OBJECTION

State Significant Development Application No: SSD-10300

Coffs Harbour Cultural and Civic Space

GORDON ST ELEVATION

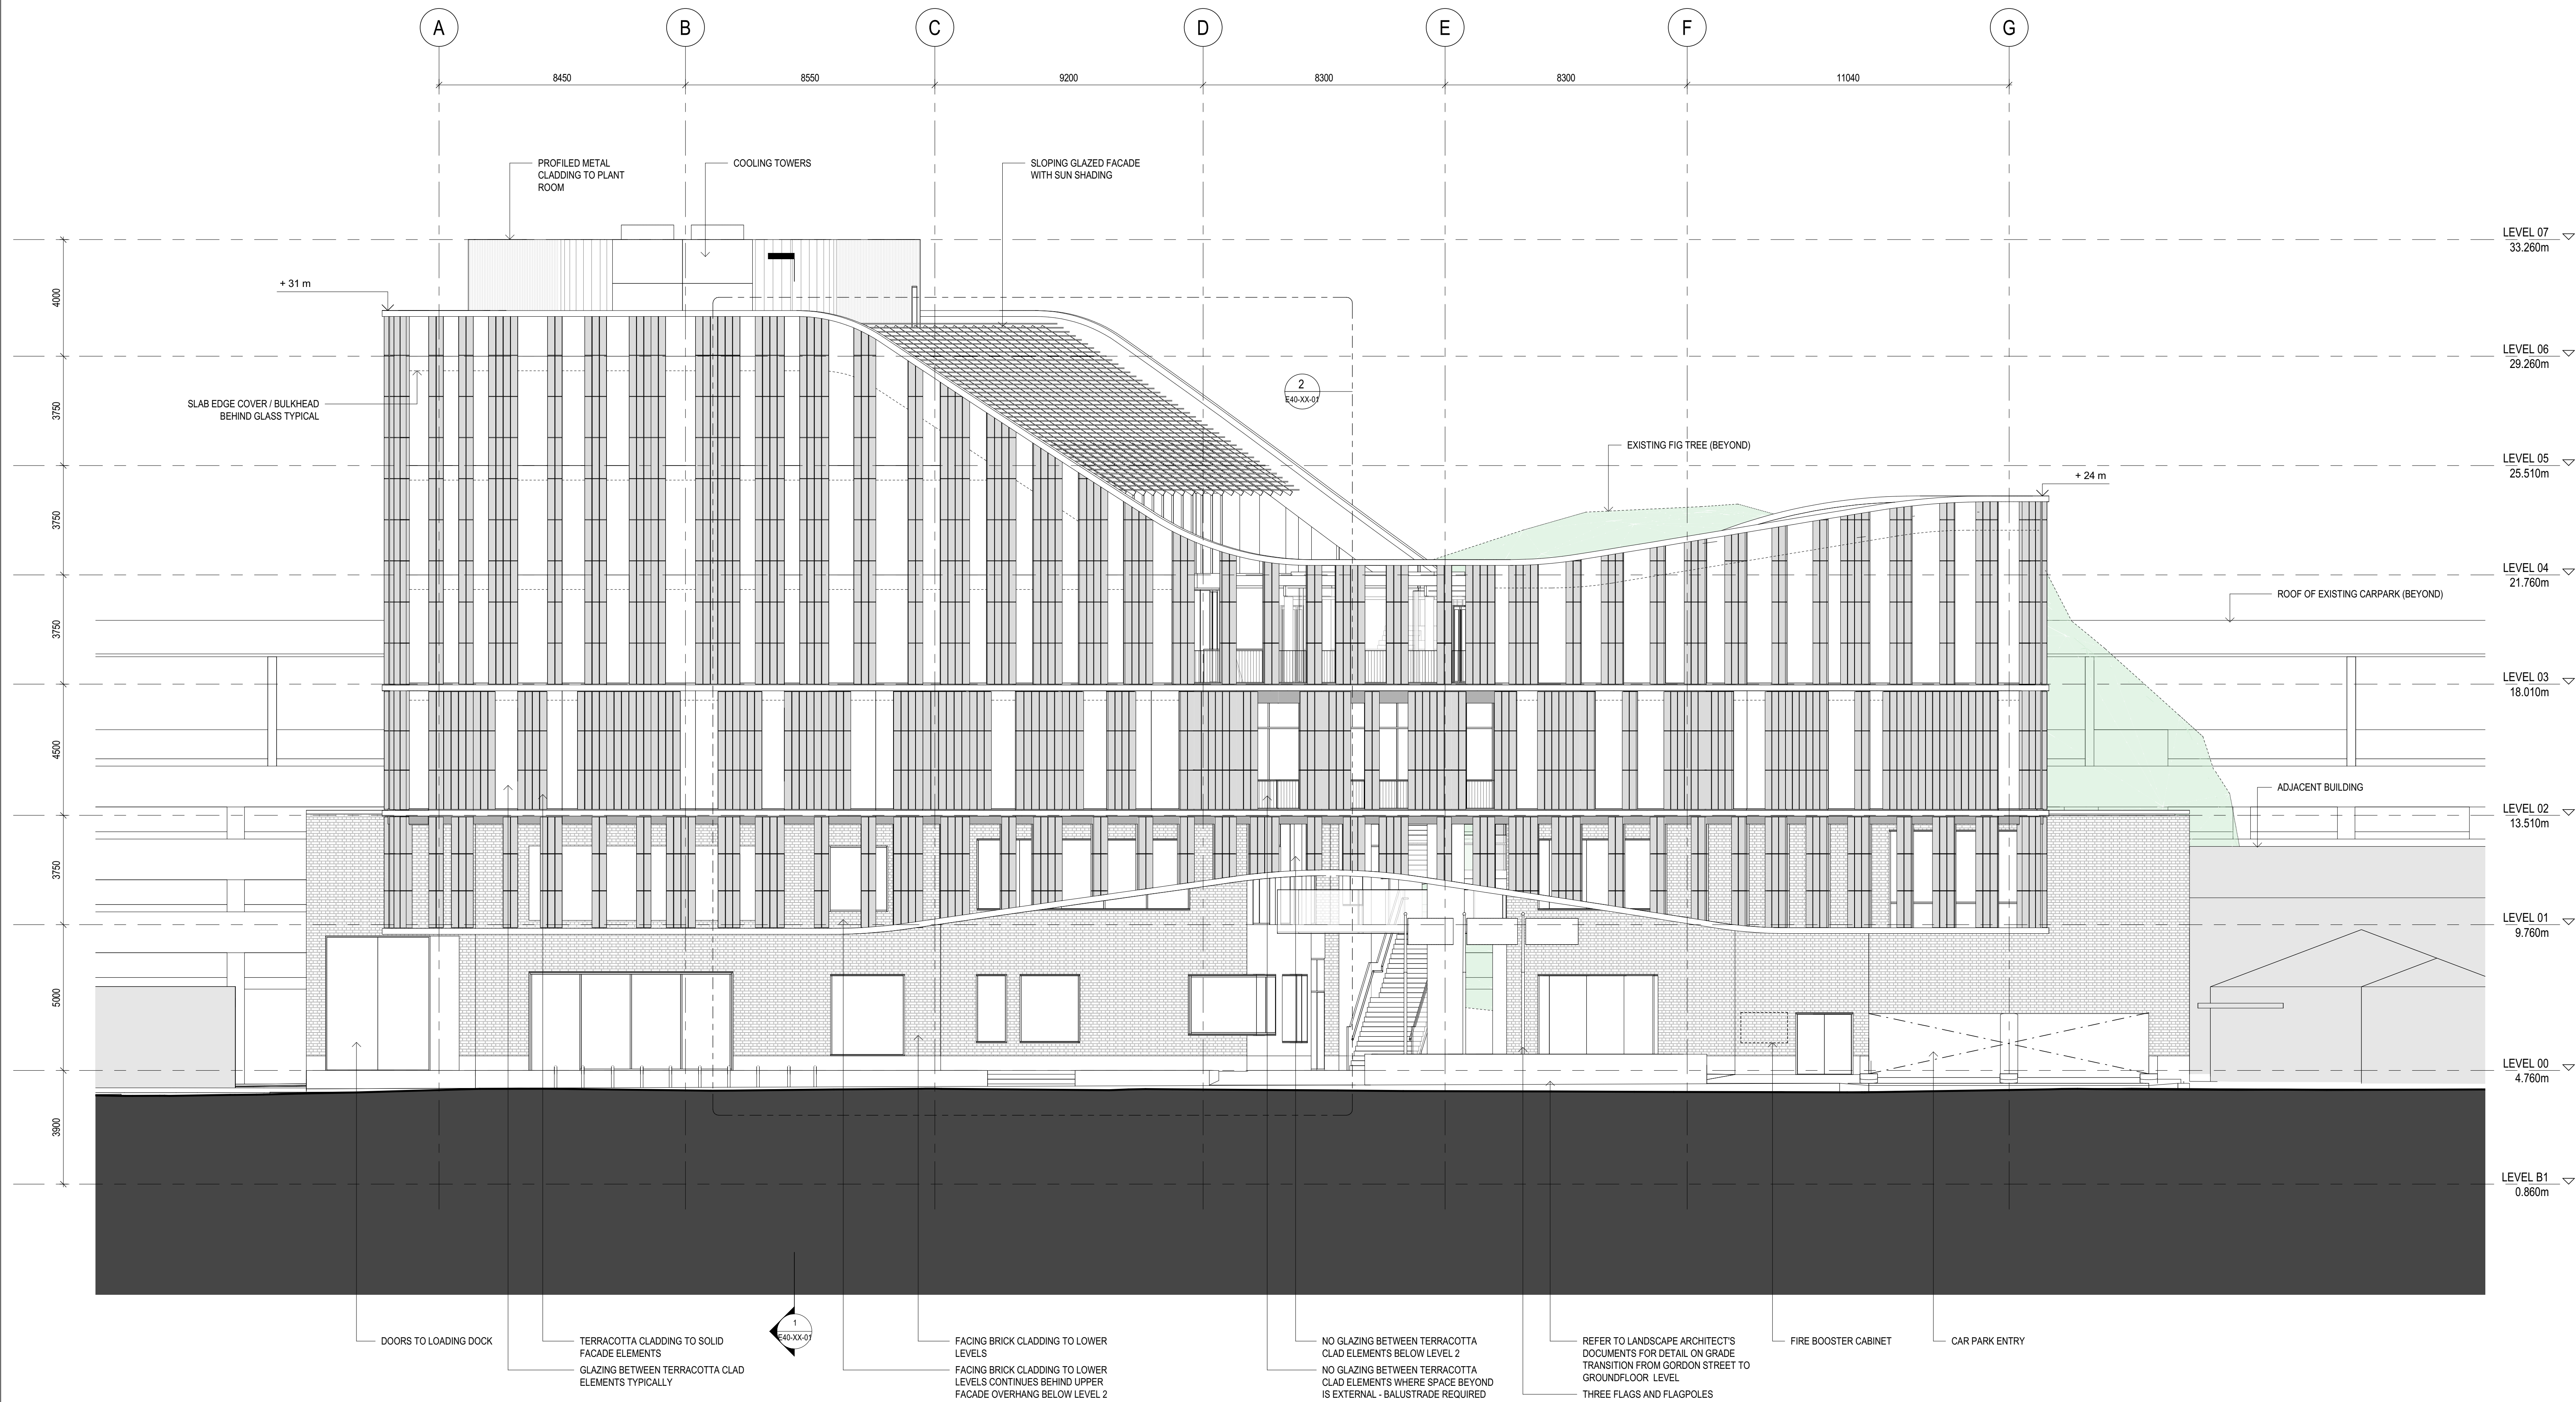
5. The proposed building is out of context in the street with no regard to scale, existing street setbacks, design and general form of adjoining buildings.

7. As a public building it fails to provide sufficient climate protection for pedestrians during storms and summer sun.
8. The building exceeds the height restriction of 28m set down in Council's own planning controls. Council's argument for variation is not satisfactorily justified and is not consistent with the objectives of the Environmental Planning and Assessment Act 1979, which requires the "the orderly and economic use and development of land". Council should not receive preferential treatment.

RIDING LANE ELEVATION

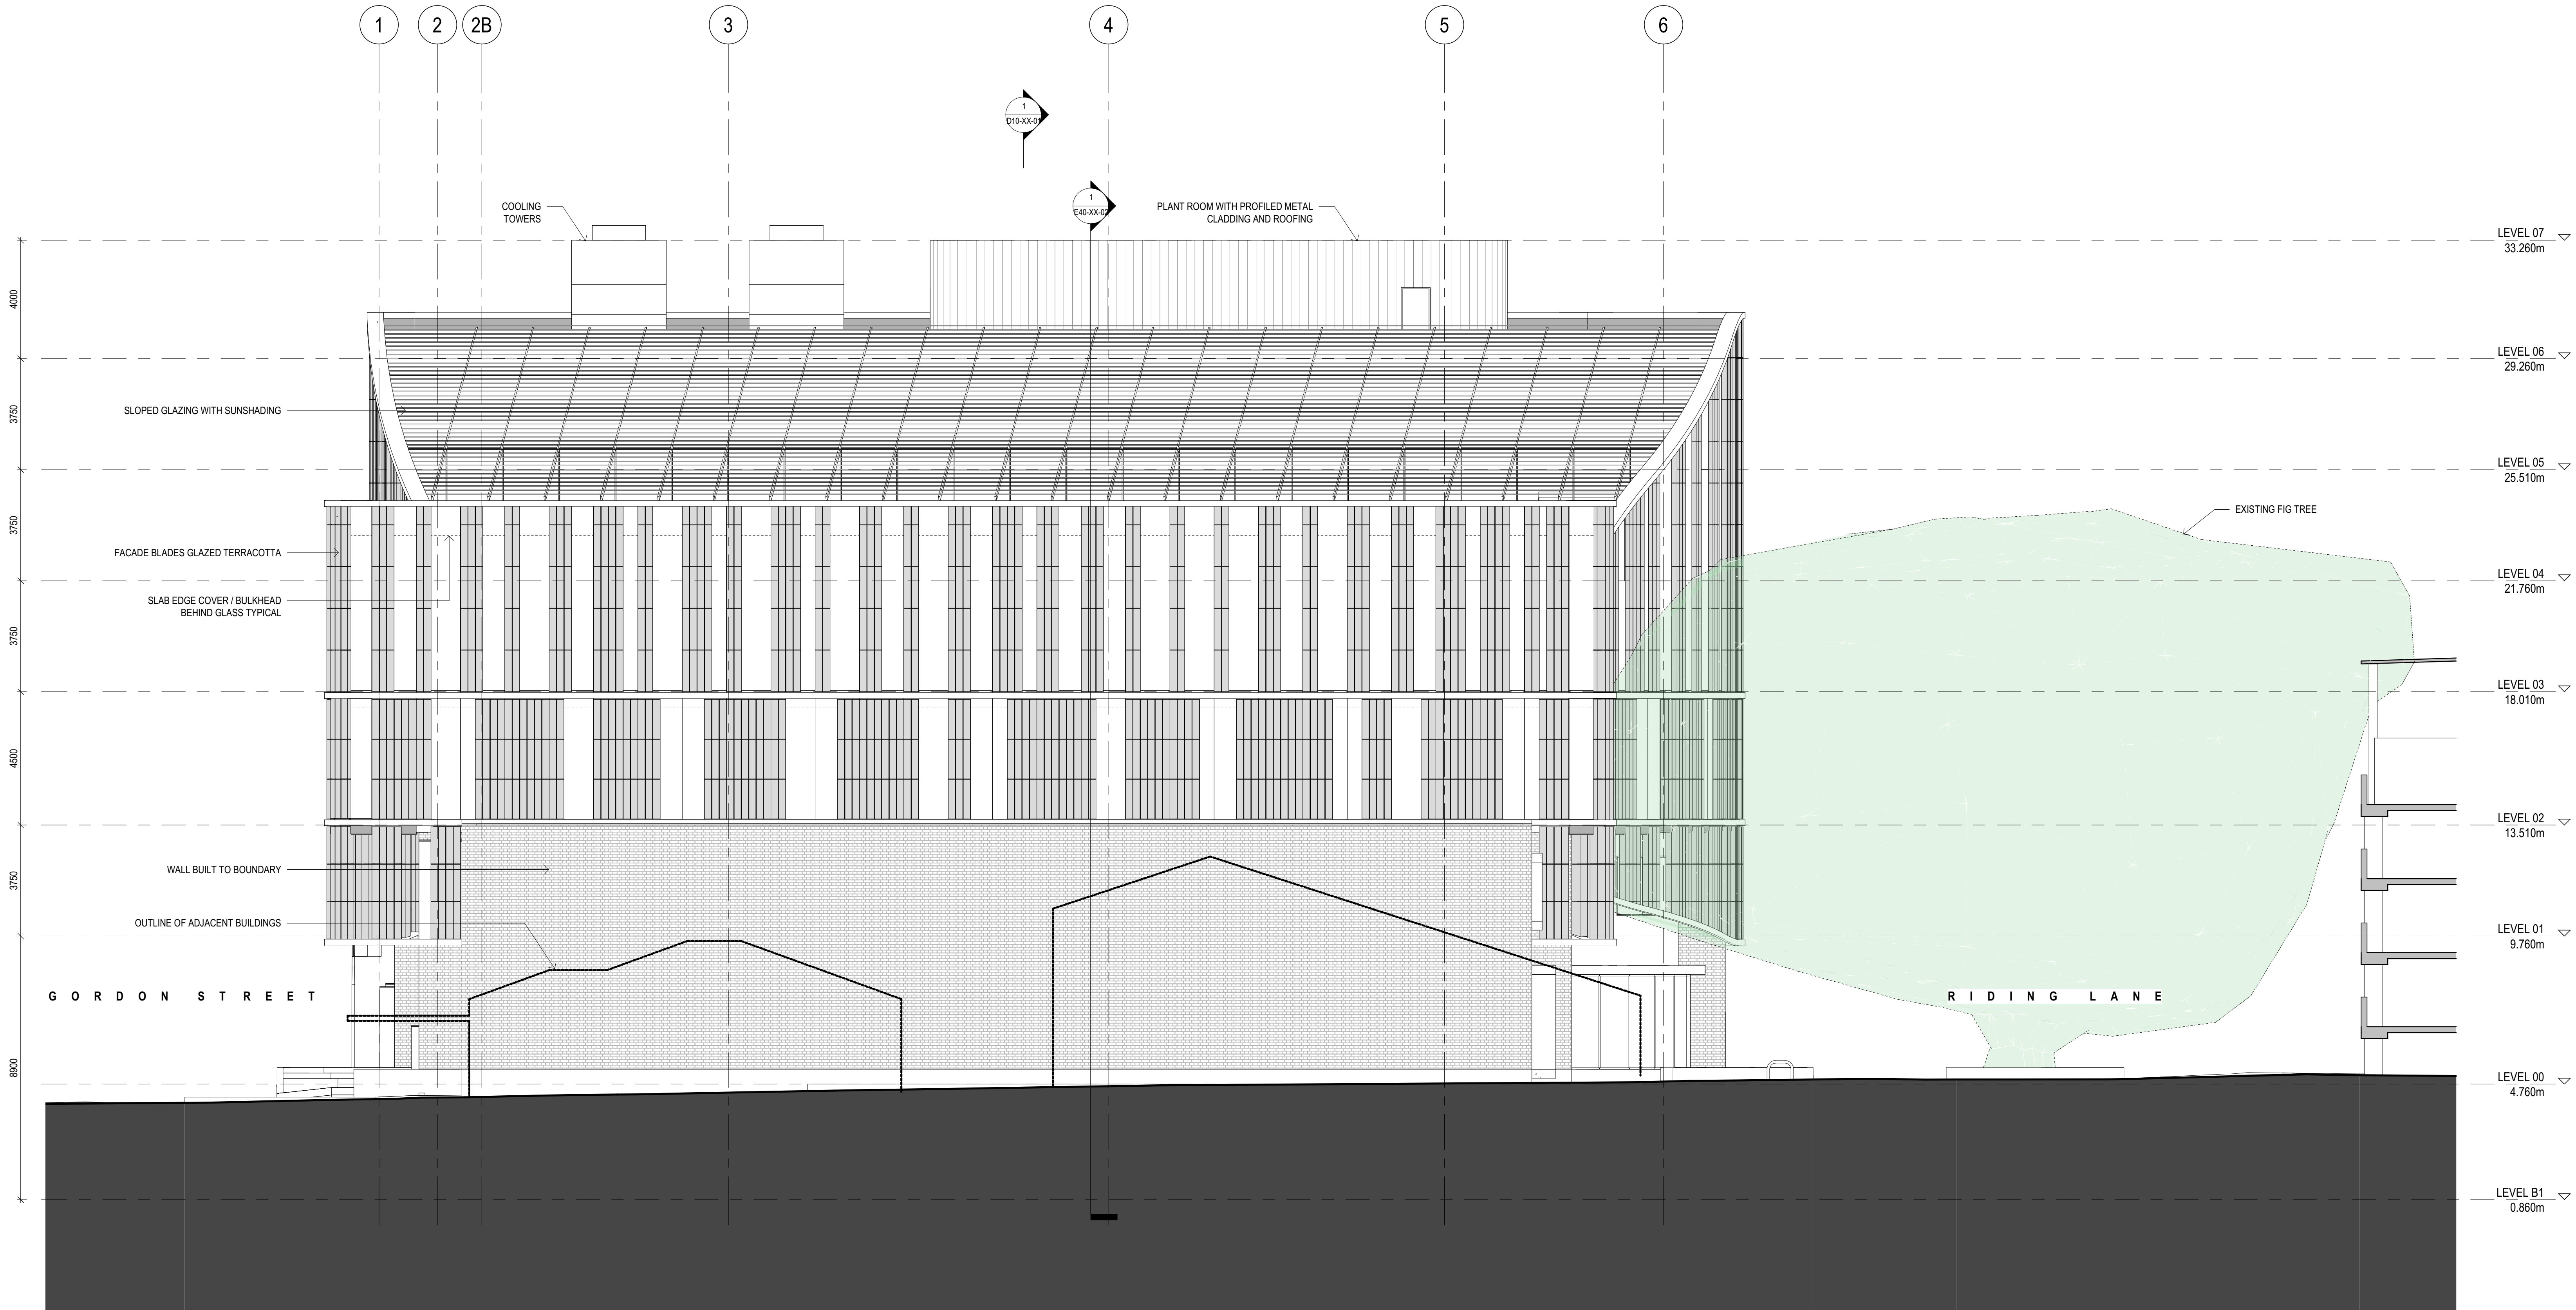
6. The proposal does not meet "safer by design" principles and guidelines, as the arcade to Riding Lane confuses boundaries and provides "hides" for criminal activity, vagrancy and prevents good surveillance.
